Botley West Solar Farm

Change Request Report

19 March 2025

PINS Ref: EN010147

Drawing 1: Site Location and Order Limits

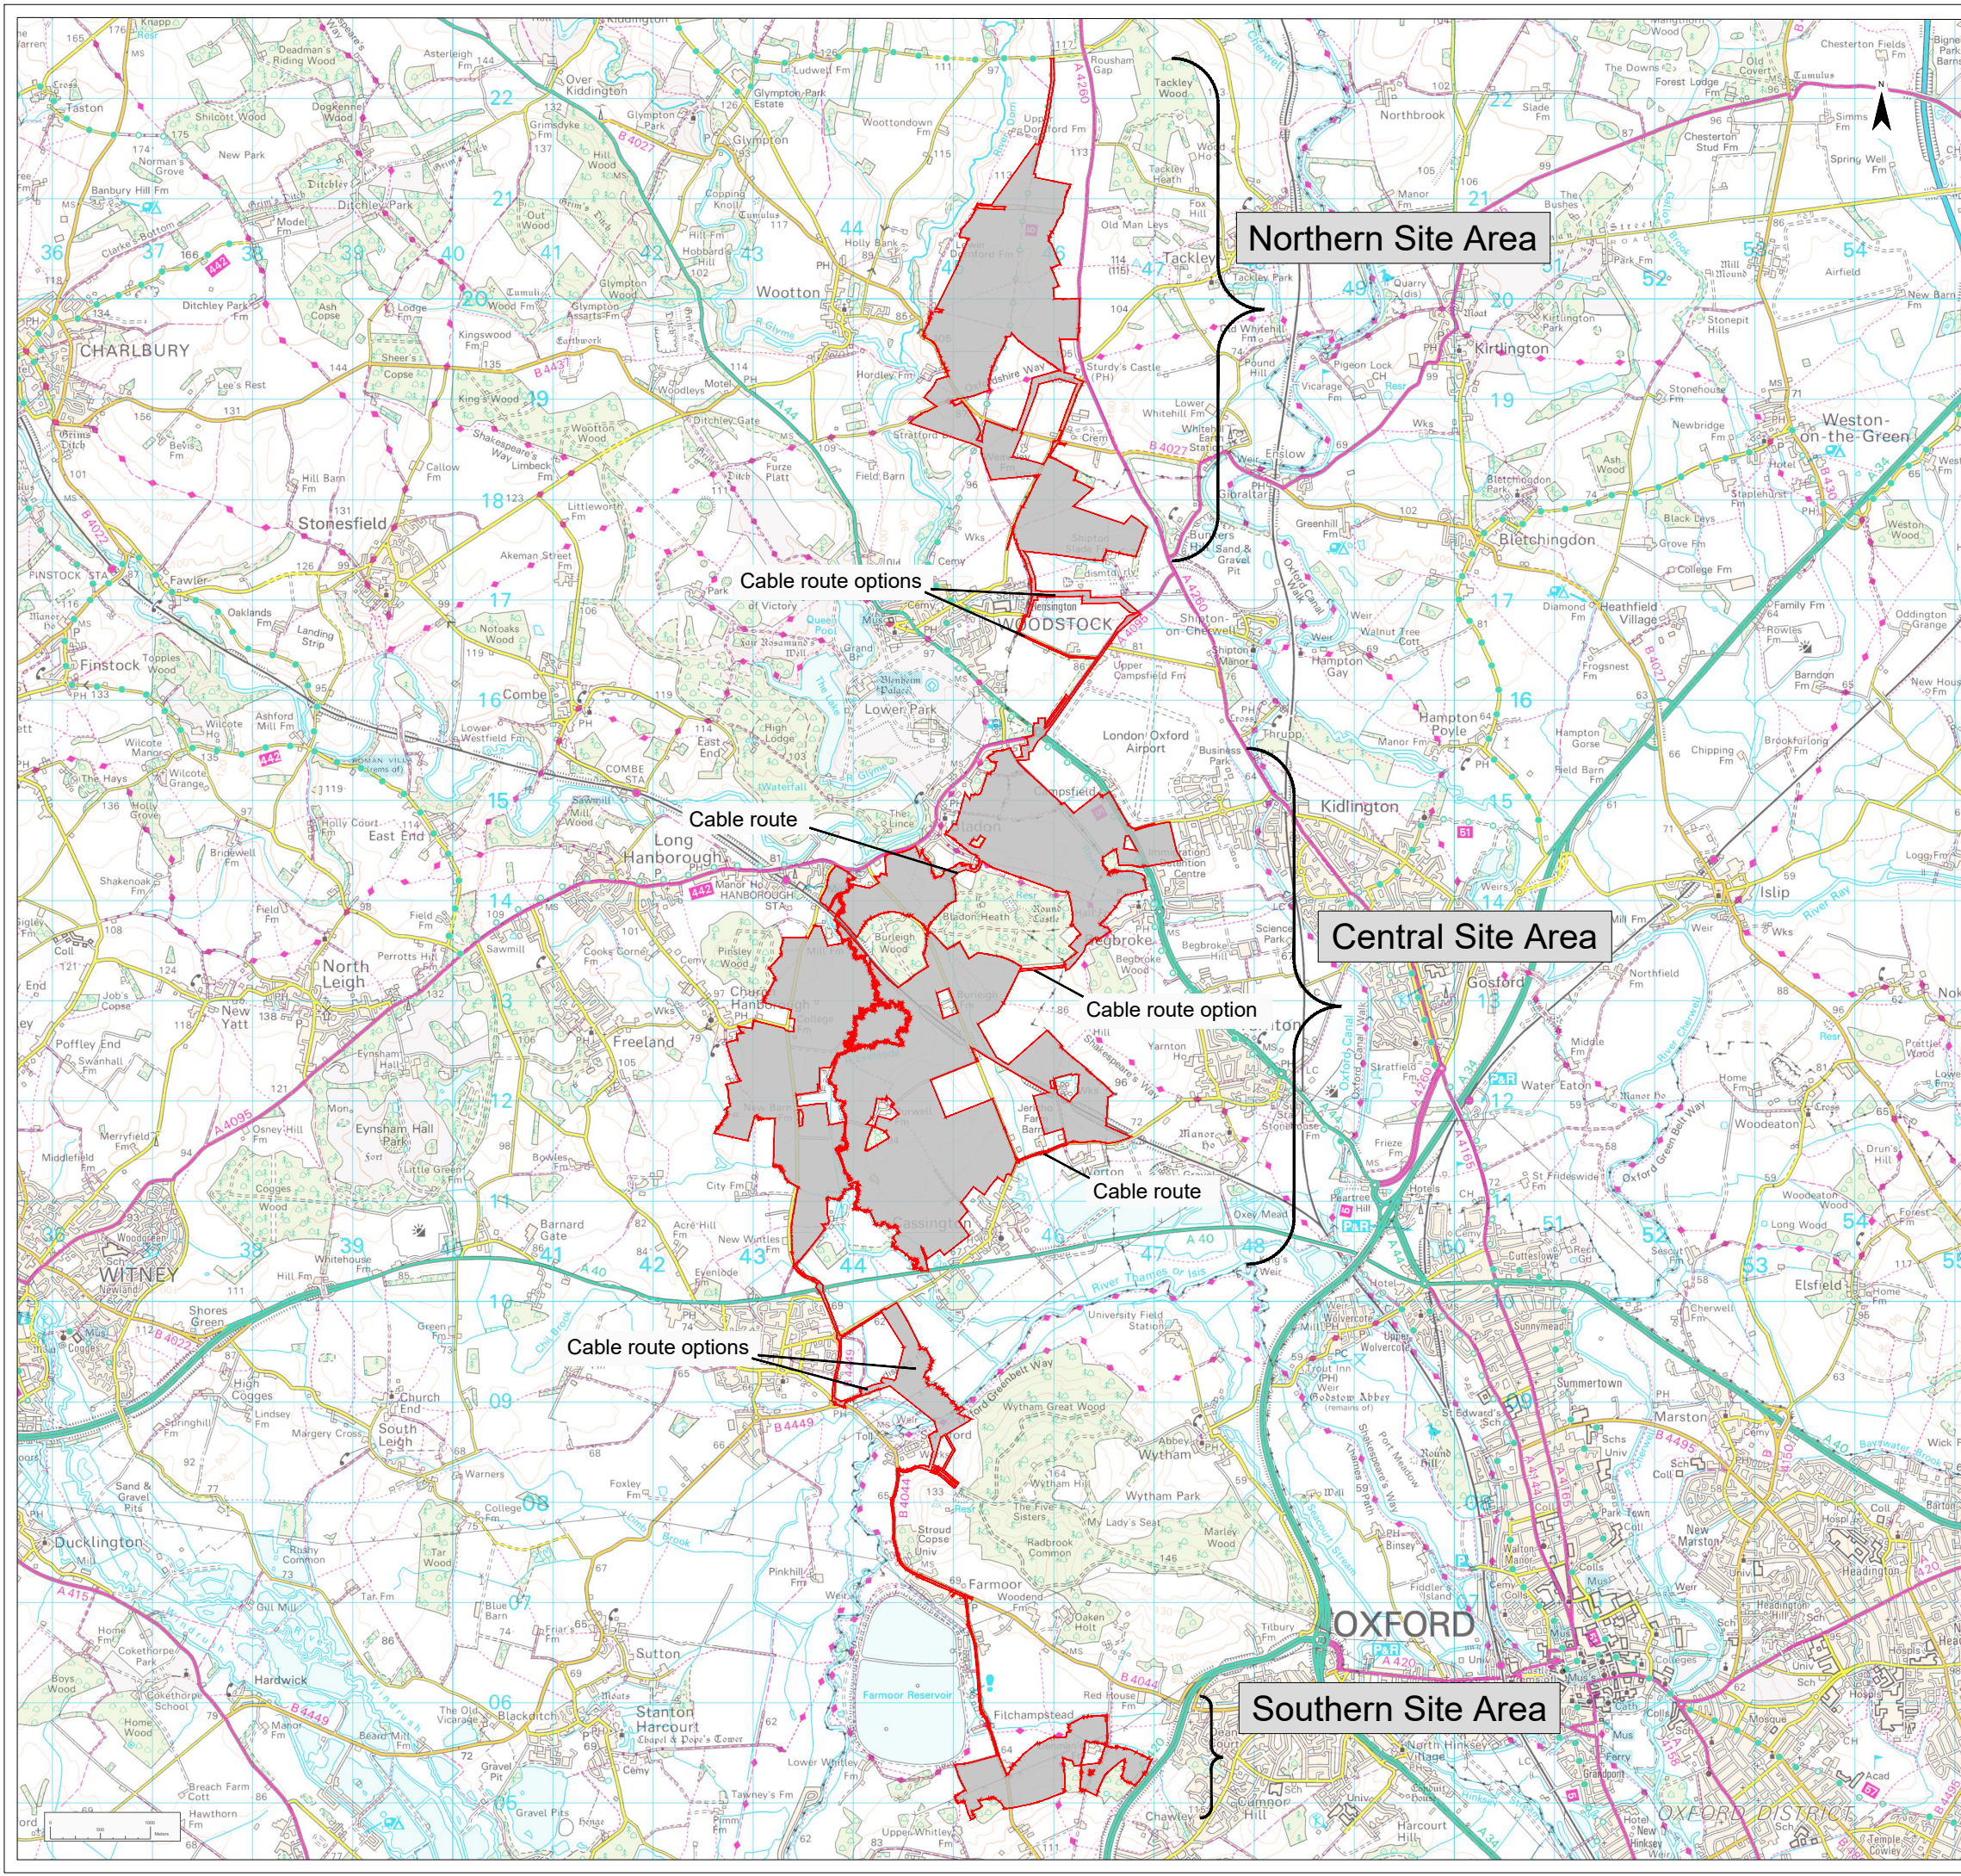
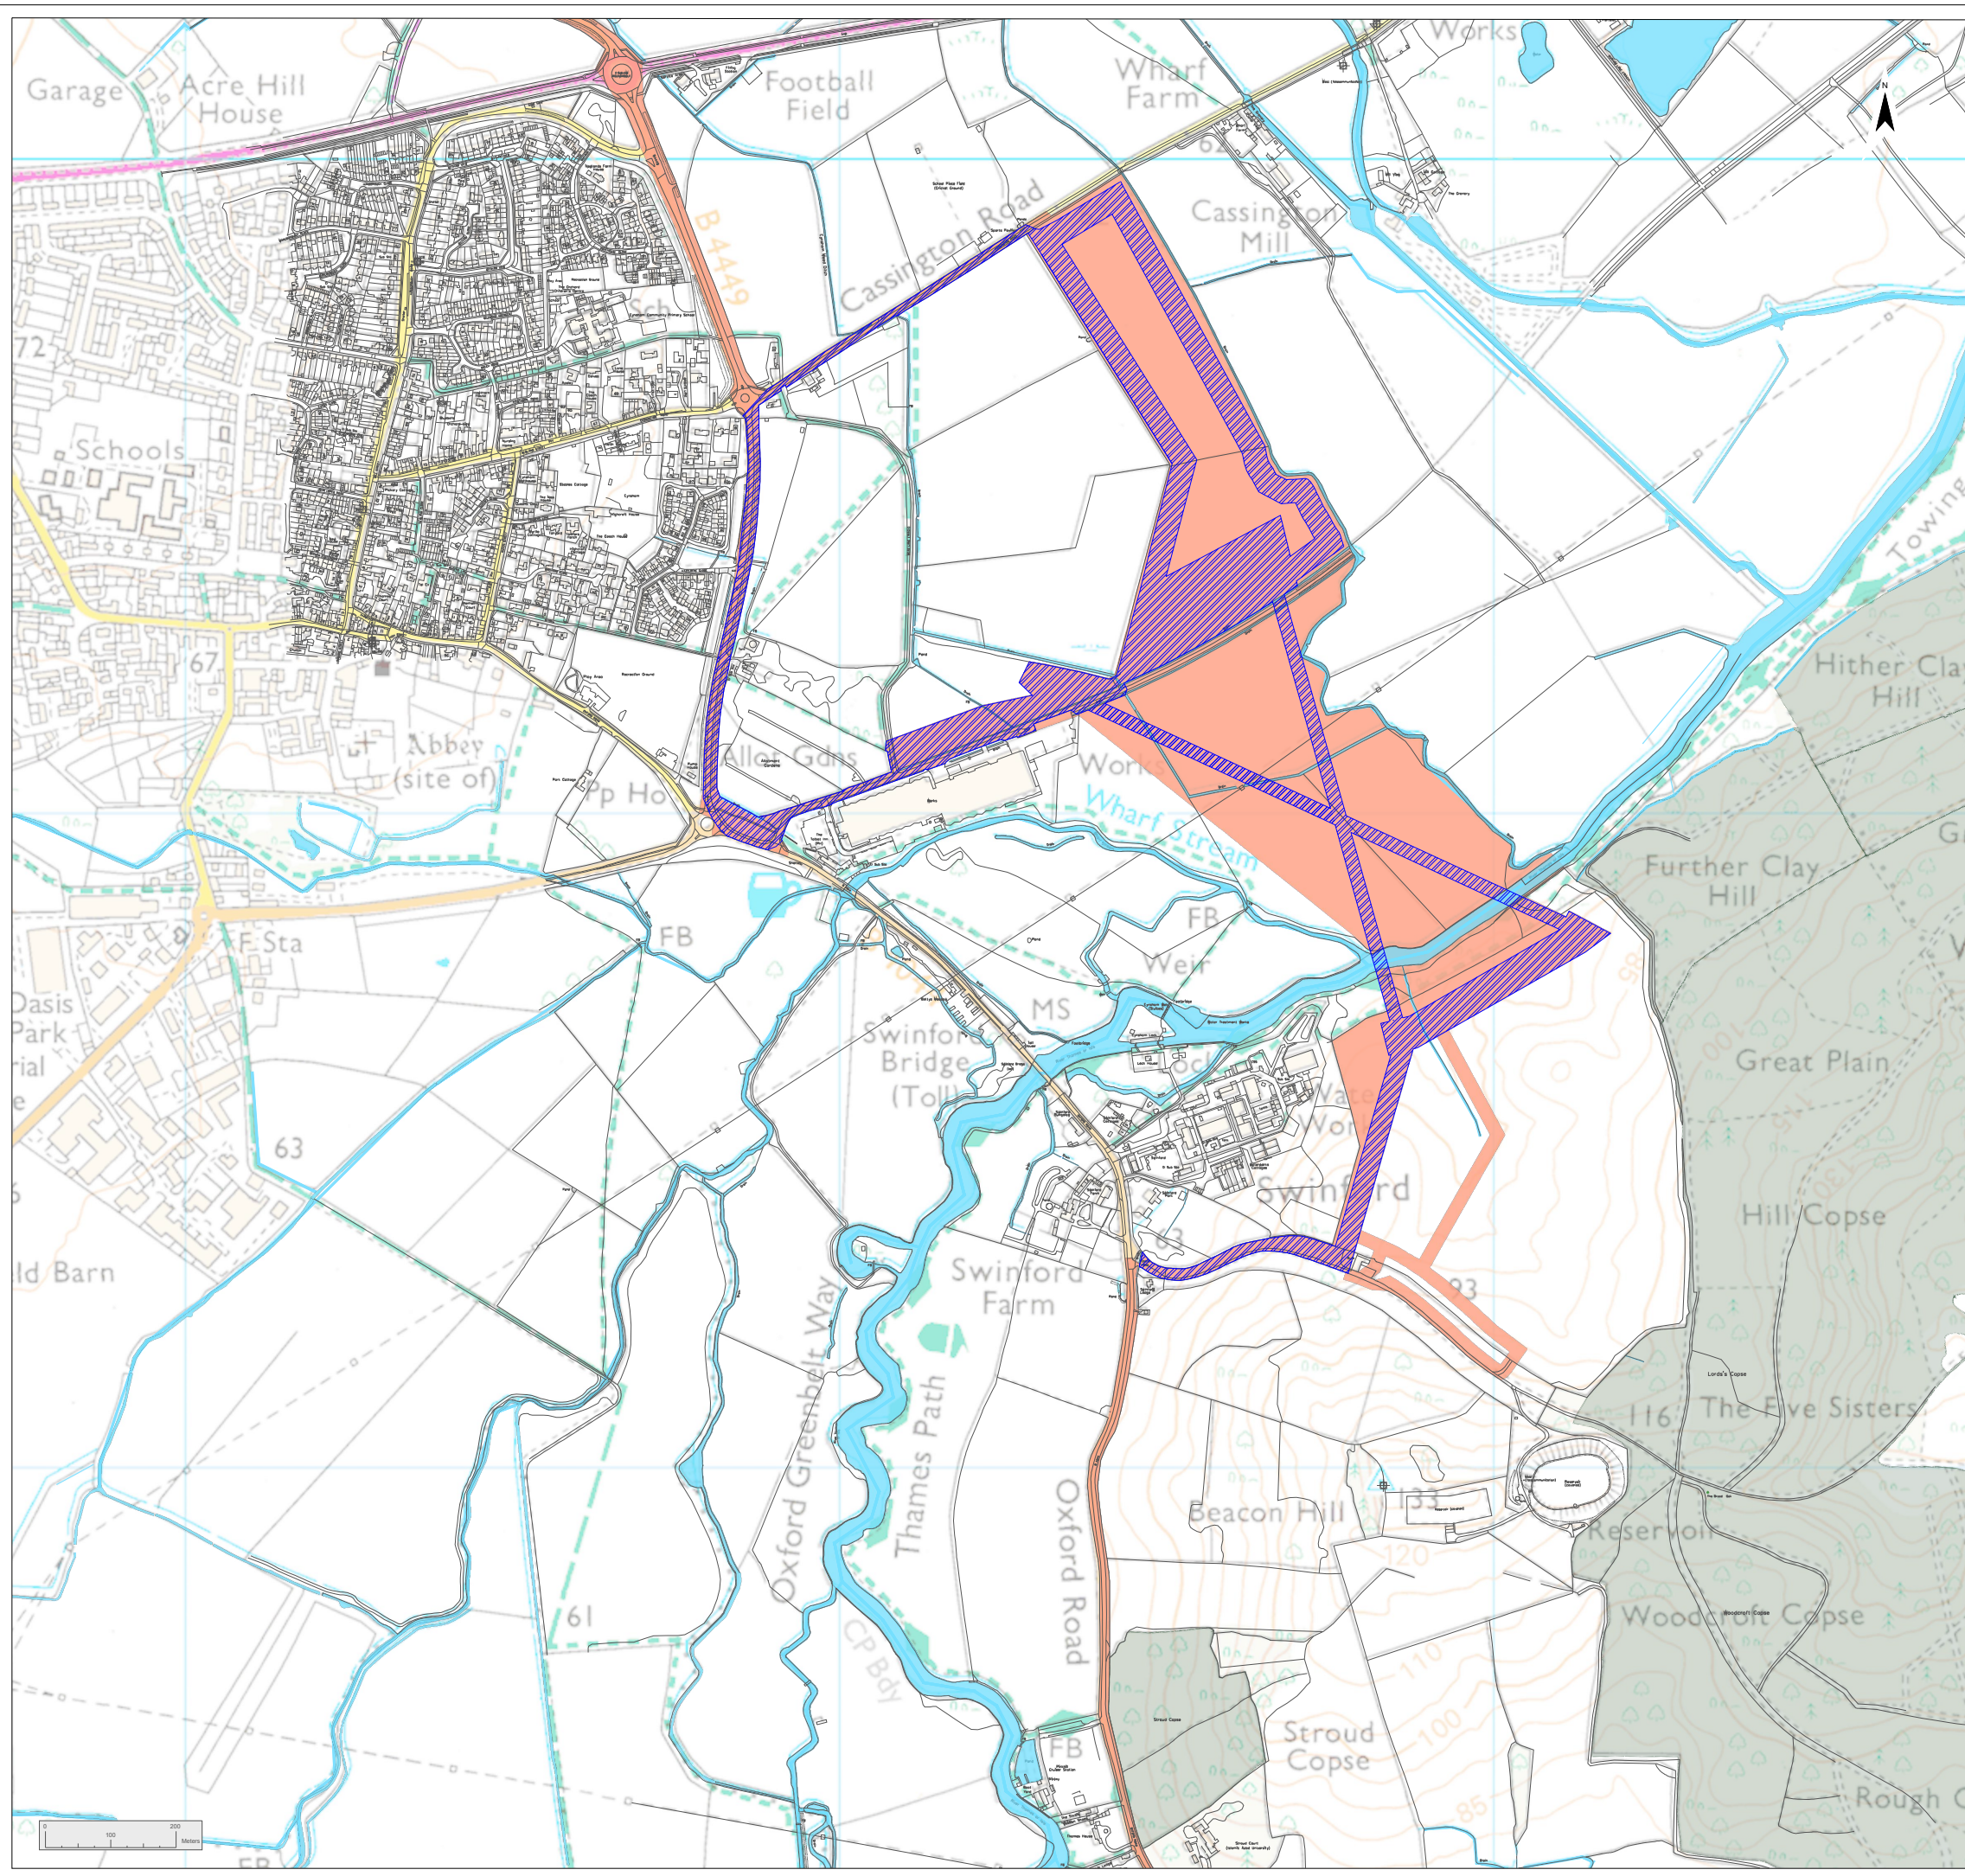
- 1.2.4 In summary, the two changes relate to:
- a. **Change 1:** Small reduction in redline (0.015 ha) to remove an access; and
 - b. **Change 2:** Replacement of two areas of solar installation for further archaeological protection and management (0.47 ha).

2.1.2 The Applicant has removed a small area of land (identified as plot 6-17 in the Book of Reference [APP-023] submitted with the application) amounting to 0.015 ha from its redline boundary. All of the plans submitted along with the Applicant's S51 Response were updated to capture this redline boundary change. For example, see Sheet 6 of the updated Land Plans [AS-006] and Sheet 6 of the updated Works Plans [AS-005] which no longer include plot 6-17. **Appendix A** of this Change Request Report illustrates the location of the Proposed Changes in relation to the Order Limits, as discussed at paragraph 1.2.9 above.
